EL PASO COUNTY PLANNING & COMMUNITY DEVELOPMENT
SIGN APPLICATION

CLIENT:
ASPEN VIEW HOMES
FILE NAME:
4X4 MesaParkway&AutumnGlen
DESIGNER:
LOREN /AARON

PROJECT NAME:
THE GLEN
ACCOUNT MANAGER:
ELISHA
DATE & REVISIONS:
04/11/12

FILE NAME:
4X4 MesaParkway&AutumnGlen

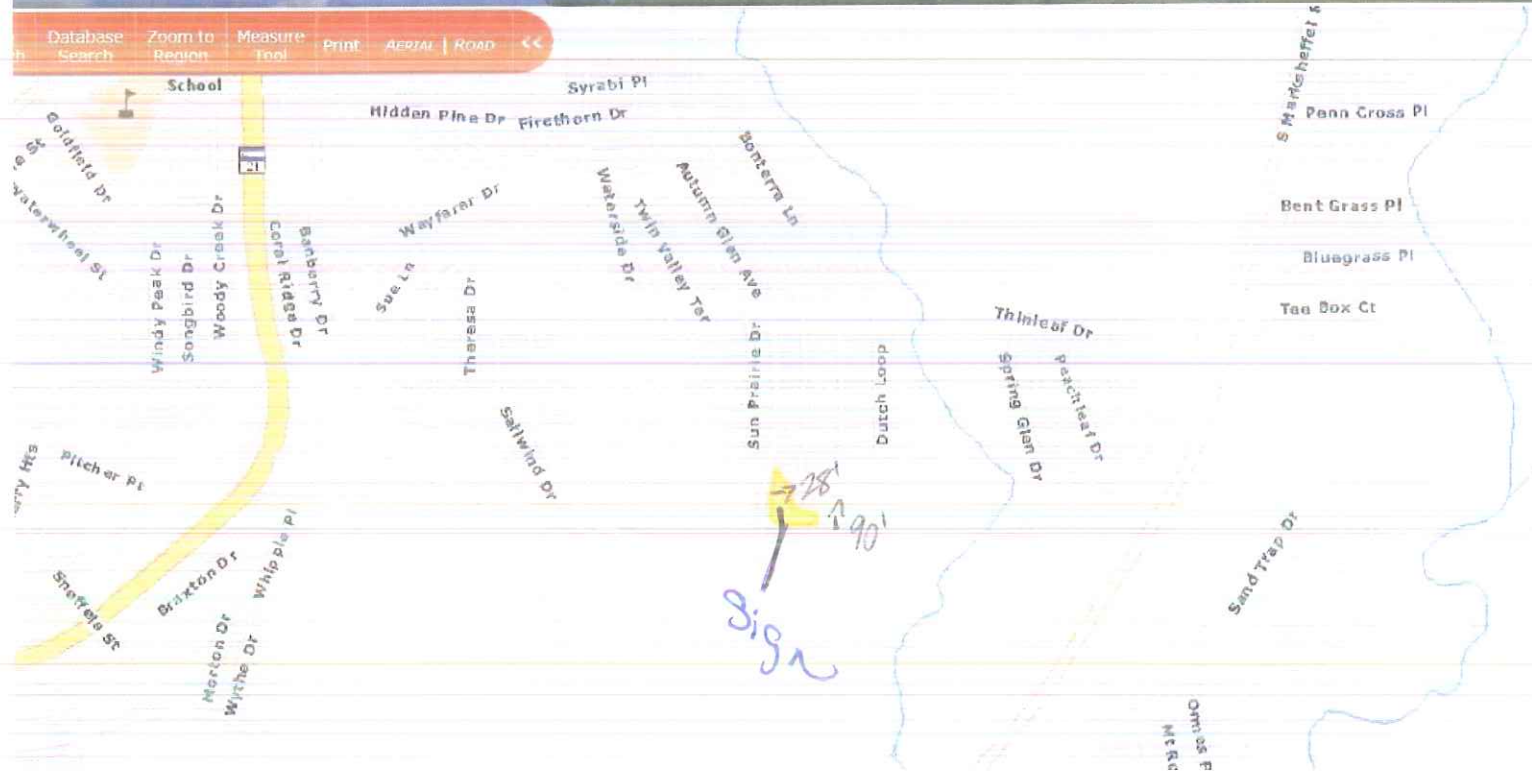
I cant see the dimensions of this sign, it states 4X4.
Please add and resubmit
